From: Sue Howell
Sent: 25 July 2016 16:20
To: Planning.Responses
Cc: Ross Leal
Subject: RE: Please find attached amendment on planning application Ref: BN/19/16/PL

Comment from Greenspace

Registered: 21-APR-16
Site Address: Land at Pollards Nursery Lake Lane Barnham
PO22 0AF

Description of Works: Demolition of vacant office building & erection of
7 No. dwellings with associated garaging &
landscaping. This application is a Departure

Client Redrow Homes Southern Counties	Scale 1:250@A2
Project Former Office Land of Pollards Nursery	By/Chk LM/JH
Drawing Title Planting Plan	Date 16/12/15
Drawing Number 2600-PP-06	Revision P4

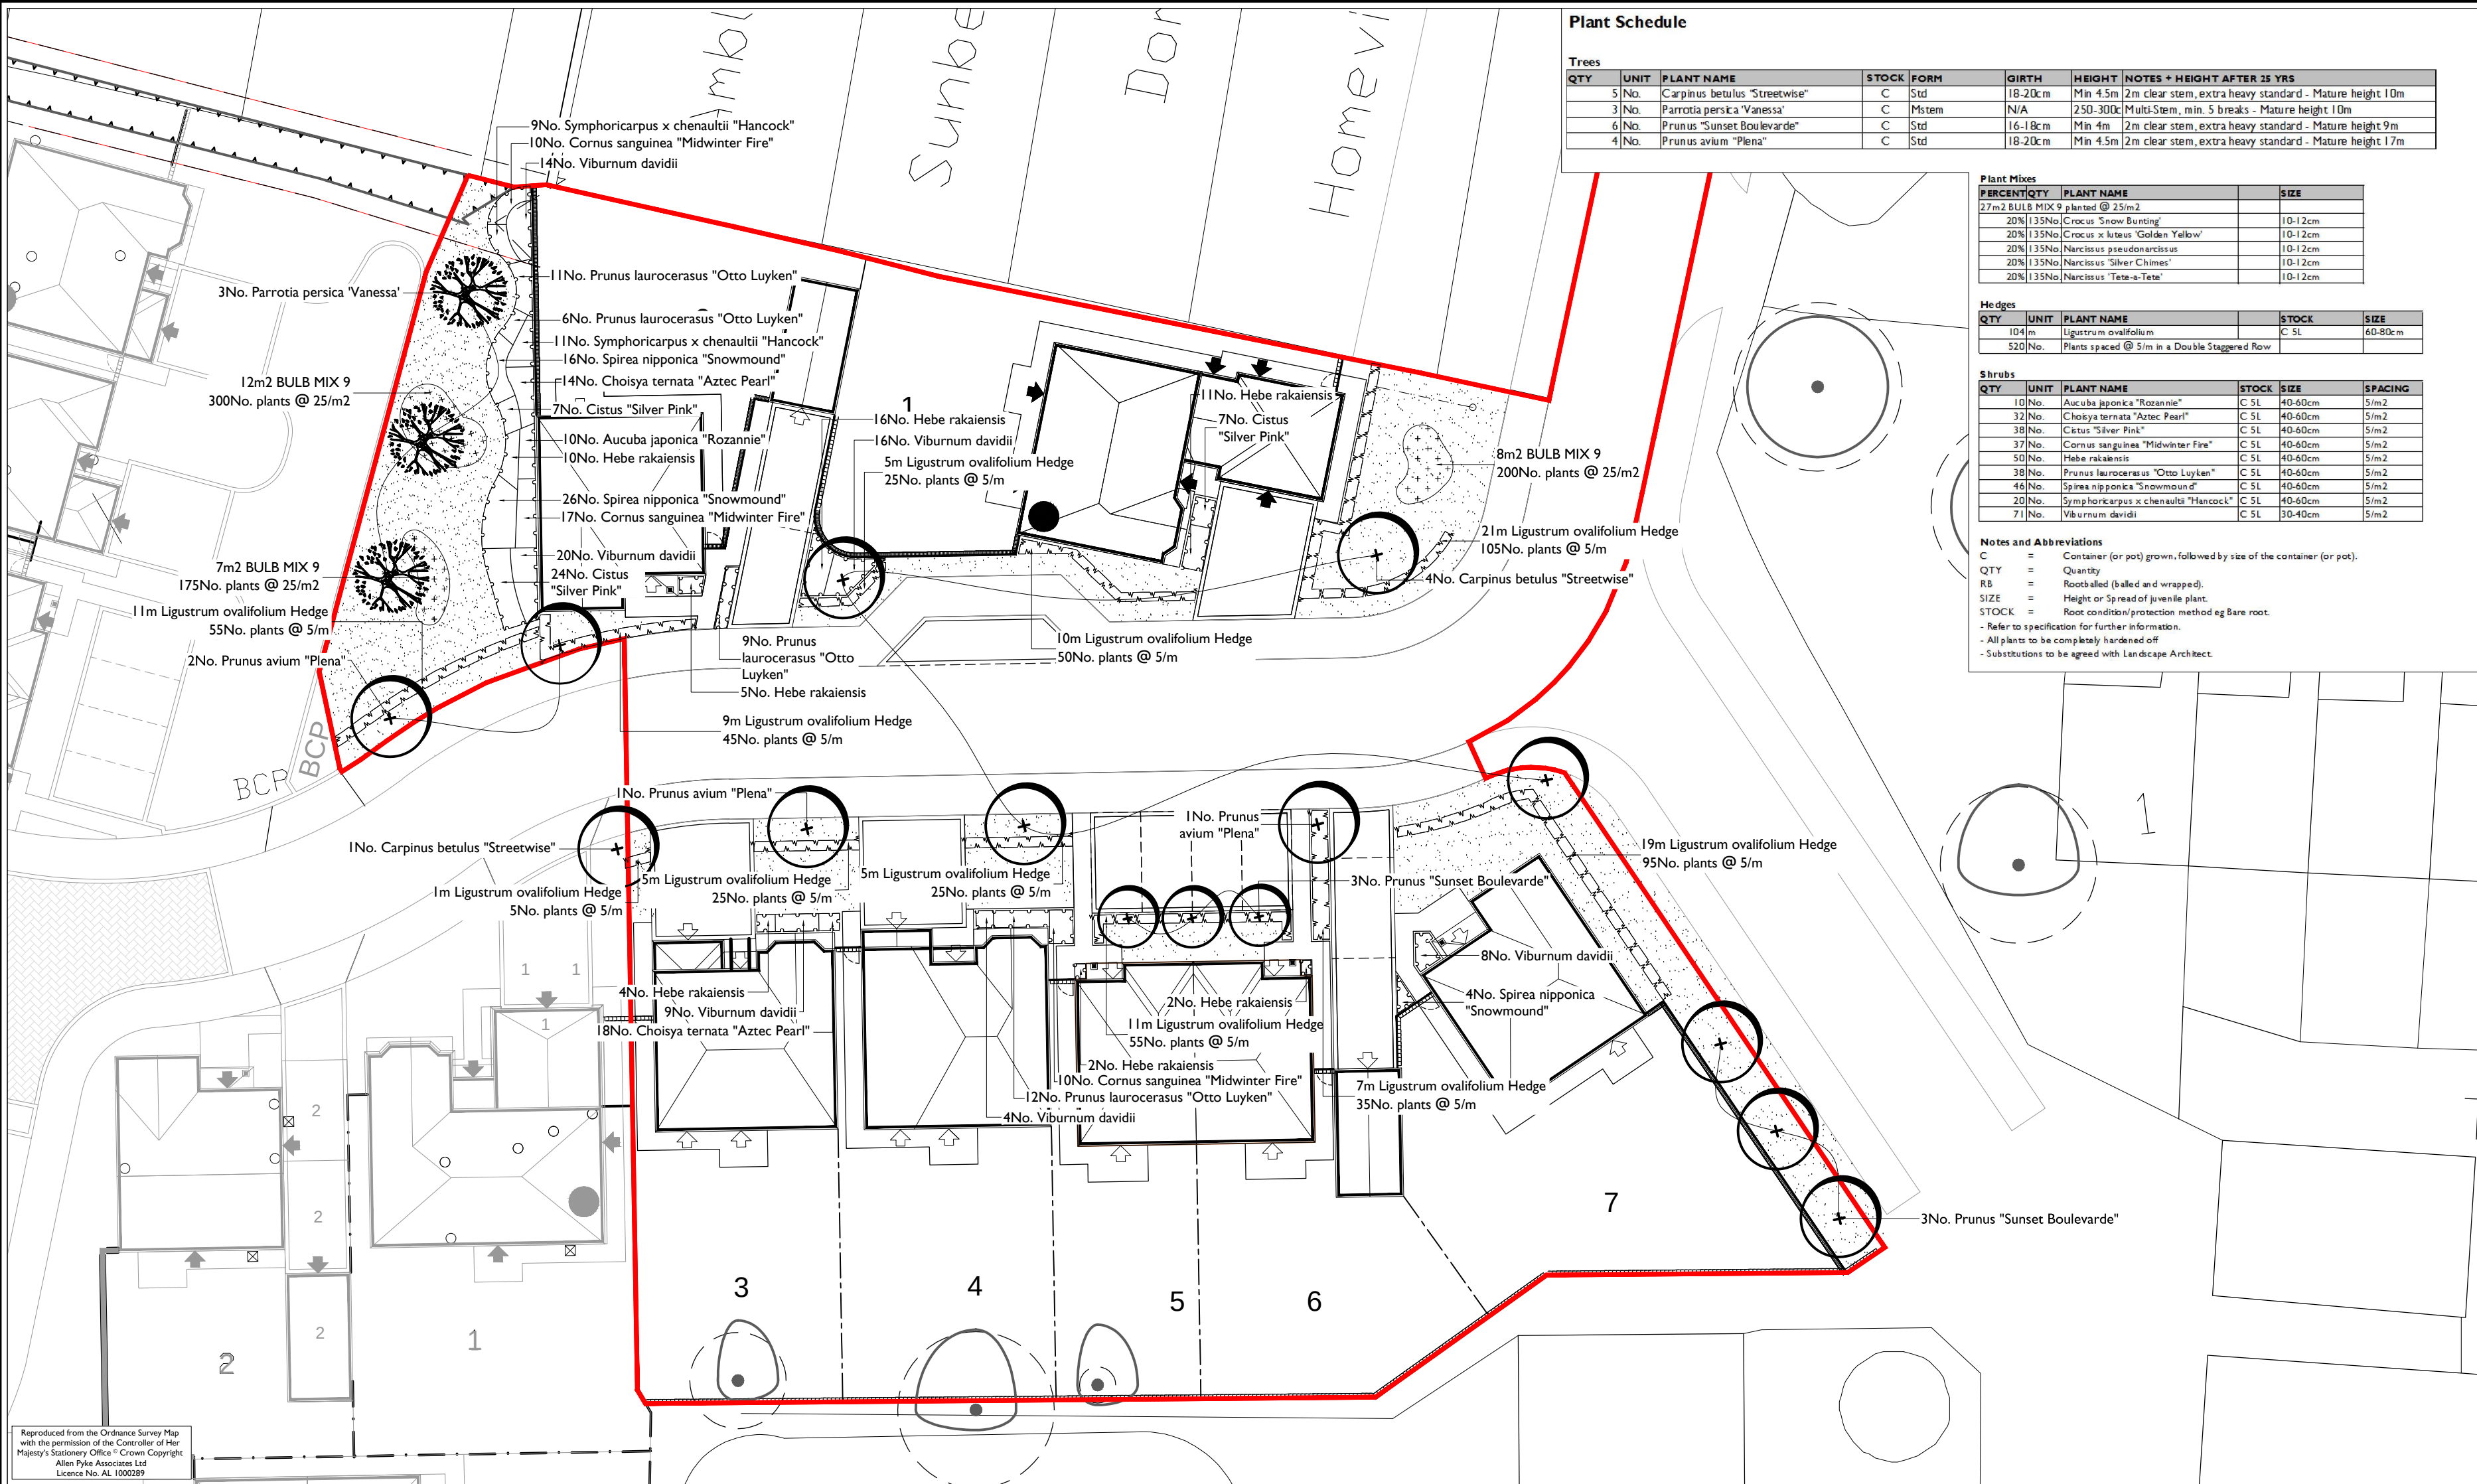
We confirm our comments submitted on 26/05/16 remain unchanged, still being valid and relevant and confirm that the revised landscape scheme submitted dwg no 2600-PP-06 rev P4 contains the information required.

No objection and no additional comment or recommendation to be made.
